Application for a non-material amendment following a grant of planning permission. Town and Country Planning Act 1990

RAISING THE EXTERNAL WALLS OF THE TWO NORTH EASTERN ARMS OF THE BUILDING TO BELOW THE HEIGHT OF THAT ALREADY APPROVED FOR THE ENTRANCE FEATURE, ALLOWING FOR ROOMS AT FIRST FLOOR LEVEL PARTIALLY WITHIN THE NEW ROOF SPACE. ALSO INCORPORATING OTHER ELEMENTS PREVIOUSLY APPROVED UNDER PLANNING REF: 3/15/0342/HH ON WHICH WORK HAS ALREADY STARTED

APP/51915/D/20/3248321

1813: 25H
1:125 at A3

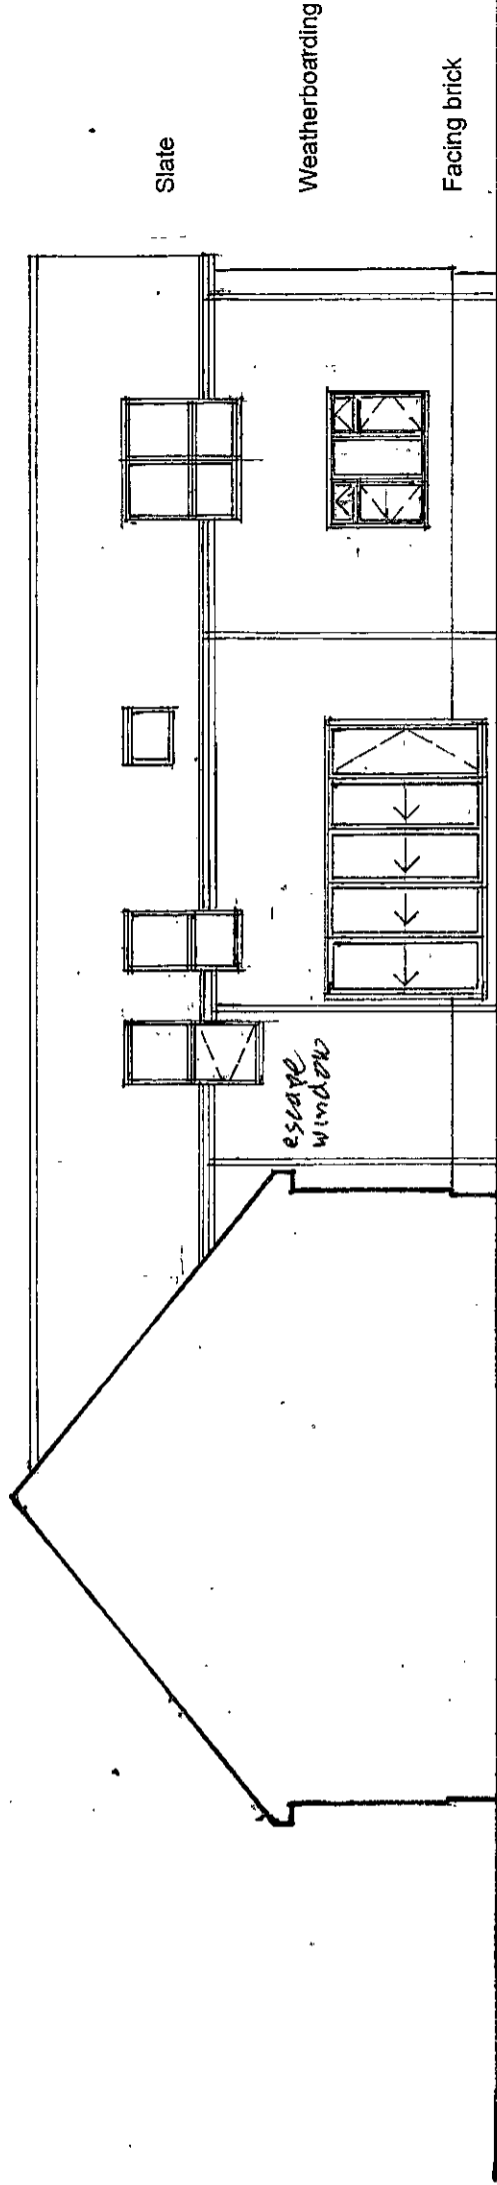
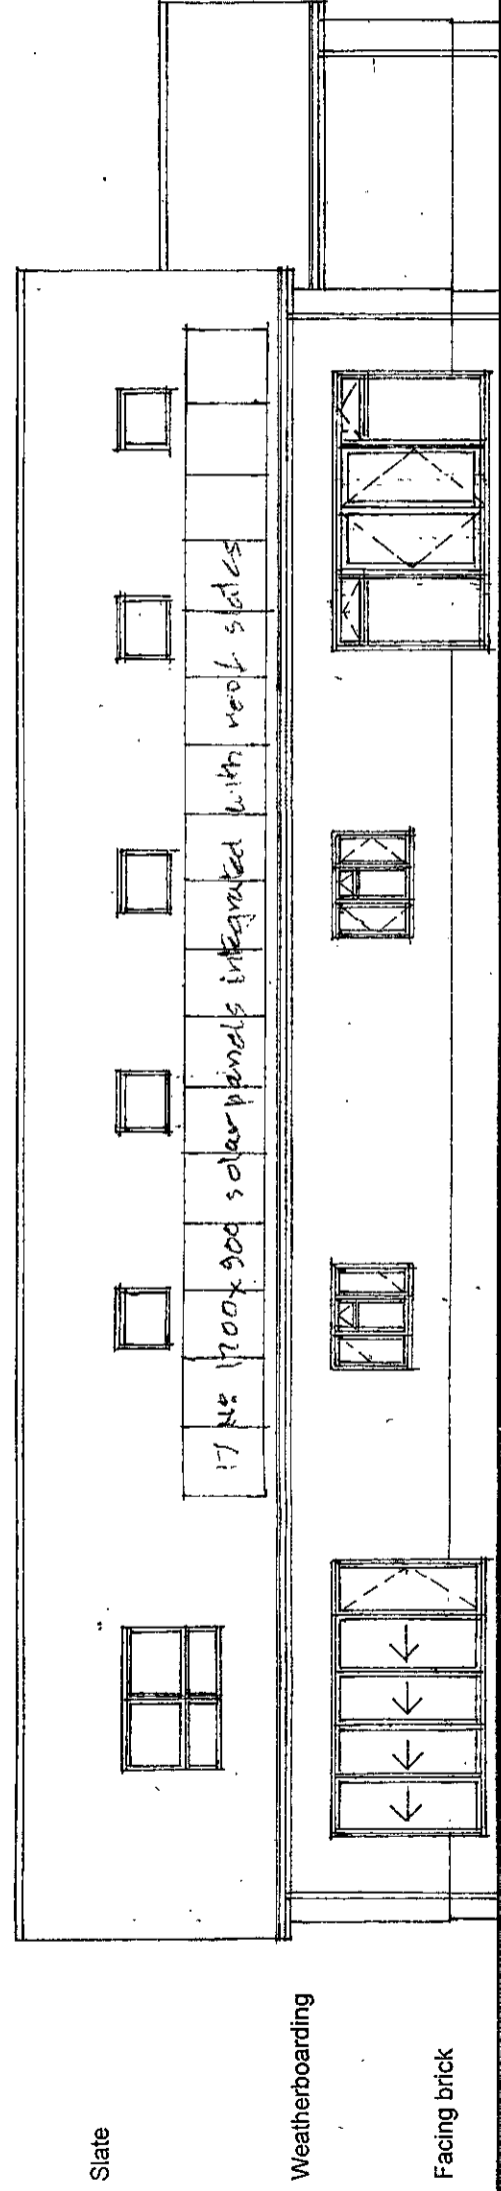
THE ORIGINAL PLANNING APPROVAL REFERENCED ABOVE WAS FOR A FACING BRICK PLINTH WITH WEATHERBOARDING ABOVE UNDER A SLATE ROOF. FOLLOWING THE GRENFELL DISASTER FIRE REGULATIONS HAVE CHANGED AND THE USE OF WEATHERBOARDING HAS NOW BECOME PROBLEMATICAL. RECOGNISING THIS THE APPLICANT WISHES TO CHANGE THE CLADDING FROM WEATHERBOARDING TO A PAINTED RENDERED FINISH.

1813:25H, 1813:26H ALSO ENCLOSED FOR FURTHER INFORMATION:- 1813:19D 123E & 24F
